**Consultation Response from KC,
Trees**

2024/93336 209, Scar Lane, Milnsbridge, Huddersfield, HD3 4PZ

**Erection of detached building to create dwelling forming annex accommodation associated
with 209, Scar Lane, Milnsbridge, Huddersfield, HD3 4PZ**

Date Responded: 30/01/2025

Arboricultural Impact Assessment Plan

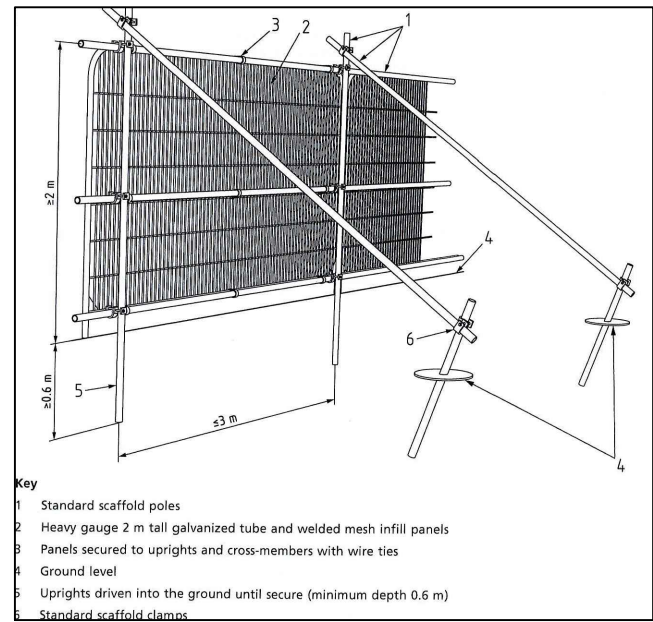
The submitted tree information shows that T1, T2, and T3 are category C trees and recommended for removal. This is a fair assessment due to their species and stature. These 3 trees are also not protected under the TPO and therefore their removal to facilitate the development is acceptable.

With the three trees removed there would be no further impact on the surrounding trees. The submitted tree protection plan also looks to provide adequate protection to the surrounding trees during construction.

There is no objection and no further comments, proving all submitted plans are adhered too.
